From: Contact Centre (CRM) <contact@ribblevalley.gov.uk>
Sent: 31 July 2022 13:58
To: Planning
Subject: Planning Application Comments - 3/2023/0678 FS-Case-440965913

Planning Application Reference No.: 3/2023/0678

Address of Development: Chipping Farm Shop

PROPOSED ELEVATIONS SCALE 1:100

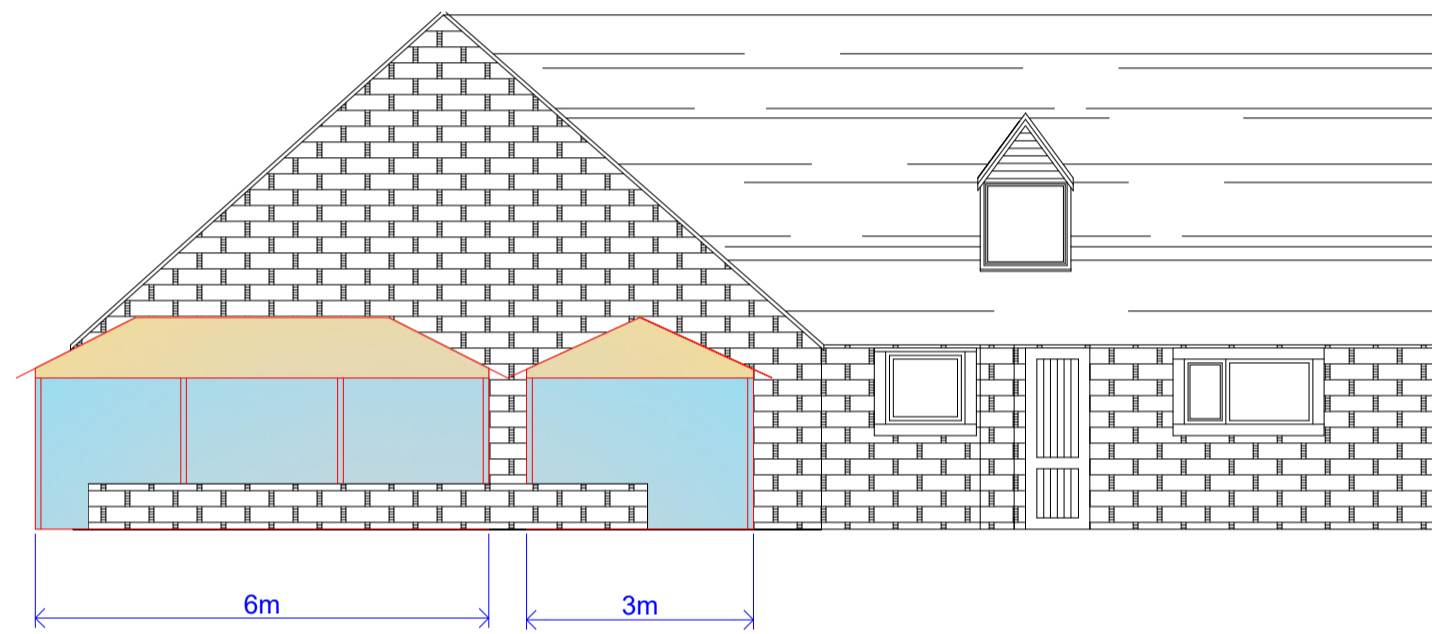
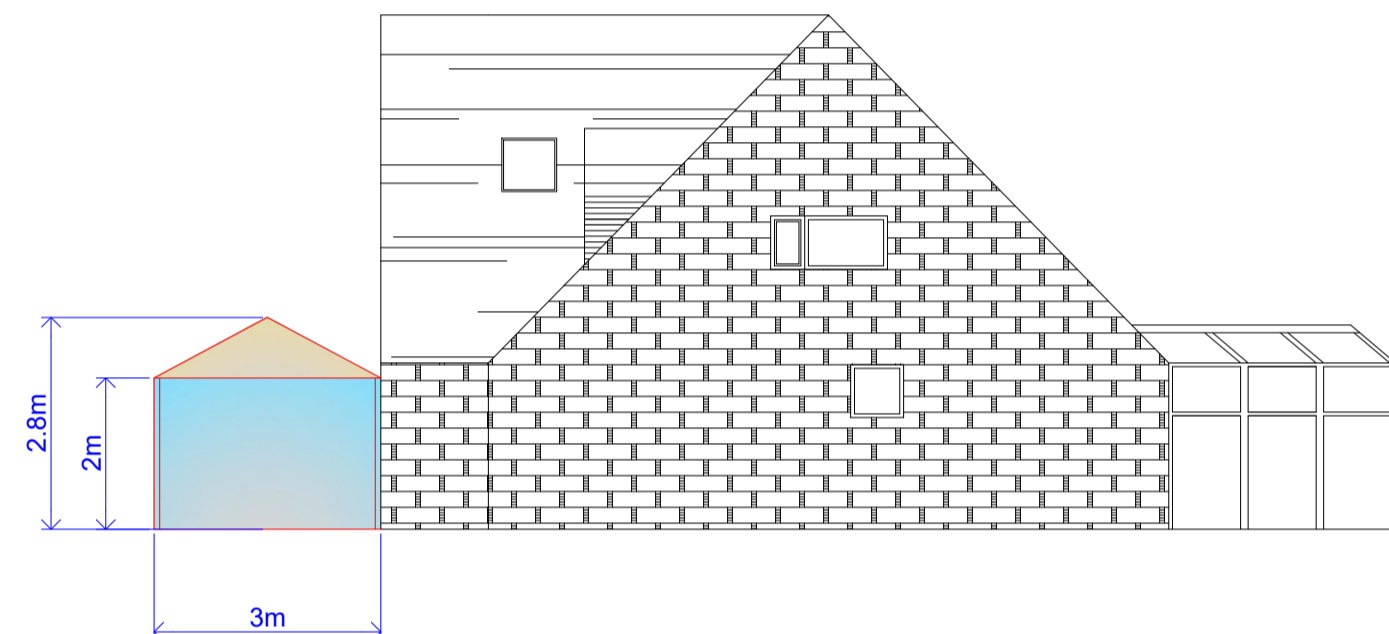
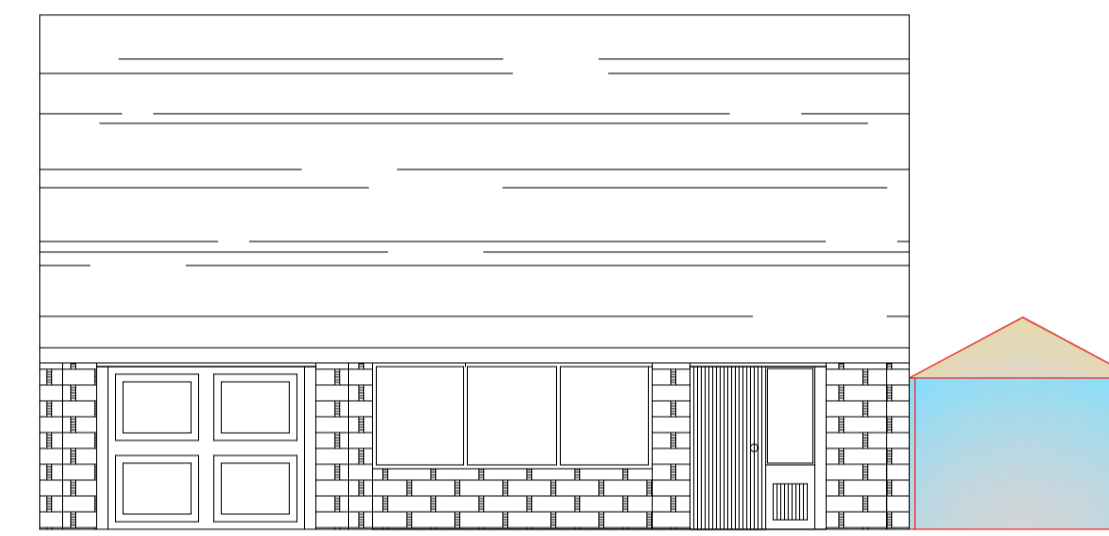
Comments: I wish to object to this application to make the temporary gazebos a permanent fixture. To me they look like market stalls and as for perspex sides, surely these can not be allowed bordering a conservation area in an historic mainly stone built village.

The two plastic gazebos on the roadside bordering a conservation area are not in keeping with the historic village. They look like temporary market stalls and visually detract from the area. I think they will look even worse if perspex sides are added. I understand that these structures served a purpose during the covid pandemic, however i do not think that they should be retained as permanent structures. There are already two cafes and two public houses in the village offering inside eating space.
